M25 junction 28 improvement scheme

TR010029

9.117 Applicant's comments on Grove Farm's Deadline 7 submission

June 2021

**Fig 3.1 - HE Indicative alignment of amended Grove Farm egress (Change 8)**

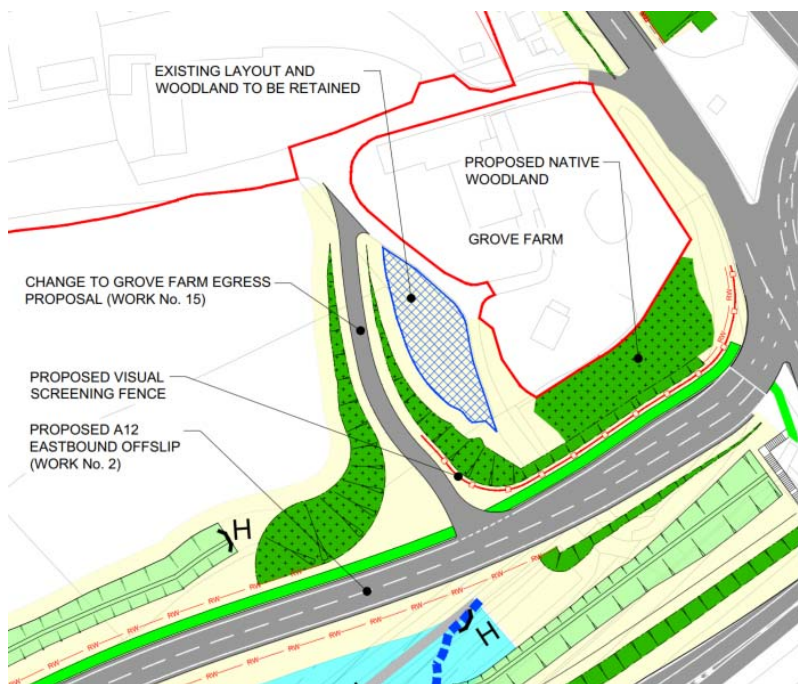
Response reference:	Representation Issue	Highways England Response
REP7-043-01	<p>We note that there has been a change 8 submitted whereby the egress is moved westerly away from the main farmhouse by a further 25m. We welcome this amendment subject to appropriate landscape mitigation and noise attenuation barriers being constructed. It is acknowledged that the length of the egress will extend from 50m to 87m, but it will move traffic away from the farmhouse. We welcome the additional tree planting on both sides of the realigned egress and although long term could provide additional visual screening, this will not reduce the noise impact over the short to medium term while these trees mature over the next 15-20 years. Furthermore, trees do not provide noise attenuation unless a buffer of at least 100ft wide is planted with dense species and again the benefit of these would take an extended amount of time to be realised.</p>	<p>Highways England welcomes confirmation from the representatives of Grove Farm that the repositioning of the egress from Grove Farm onto the A12 eastbound off slip (Change 8) is supported albeit conditionally. The ExA has submitted its response to the proposed change request submitted by Highways England at Deadline 7 (REP7-029) and is requesting views from the owners of Grove Farm, and other Interested Parties, as to the materiality of Change 8 by Deadline 8 before making a decision on whether the change is to be formally accepted.</p> <p>With regard to landscape mitigation, Highways England welcomes Grove Farm's support for the additional tree planting proposed by Highways England as shown on the change request drawings submitted at Deadline 7 (REP7-030) and that it could (or in Highways England's view would) provide long term additional visual screening.</p> <p>The proposed woodland planting alongside the repositioned egress mainly functions to provide visual mitigation to impacts from views of traffic and biodiversity mitigation to offset the associated loss of woodland. It has not been designed for noise mitigation as the space in question is insufficient to achieve this function.</p> <p>With regard to noise attenuation, please see response to REP6-041-17 in (REP7-024) which sets out Highways England position</p>

**Figure 3.2 – Grove Farm's suggested location for extra noise attenuation fencing**

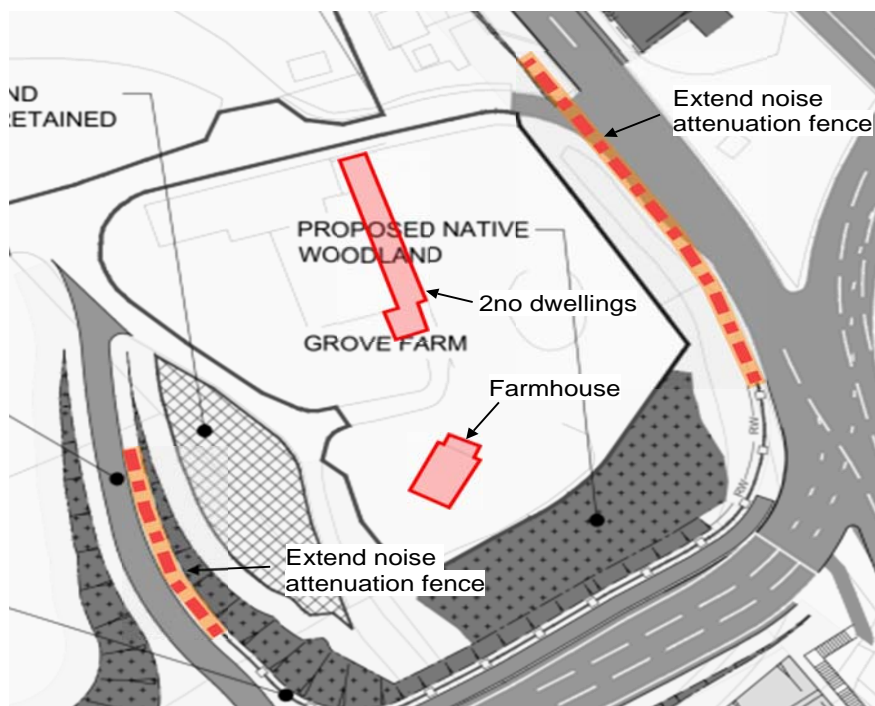
REP7-043-18	<p>This is why we need as a minimum the noise barrier around the front of our properties if not the side as well, our bedroom windows face directly on to the new proposed slip road.</p> <p>The noise will also impact our grandchildren's lives as we have previously mentioned</p> <p>Above. Young children should not be faced with increased noise such as is expected to be faced with.</p>	With regard to noise attenuation, please see response to REP6-041-17 in (REP7-024) which sets out Highways England position that a noise barrier is not required and explains why this is the case. Highways England is taking the steps that are appropriate and proportionate to address the effects of the Scheme on Grove Farm.

Response reference:	Representation Issue	Highways England Response
REP7-043-19	<p>If a visual barrier is already being proposed which will need large foundations we cannot see how a noise barrier would be much more in the overall cost of the scheme.</p>	<p>Please see Highways England response to REP6-041-15 set out in REP7-024.</p>
REP7-043-20	<p>Security is also of importance to us and we would like to see the proposals for security during the works and on completion. At the moment we have the river and field and fencing</p> <p>To protect us from unwanted intruders and security gates, these will all be gone.</p>	<p>During the construction works, security measures may include hoarding, gates, motion detector cameras and security personnel. The security position as regards Grove Farm throughout the construction and once it has been completed will be equivalent to the current position if not improved. The detail of these arrangements will be discussed with the landowner.</p>
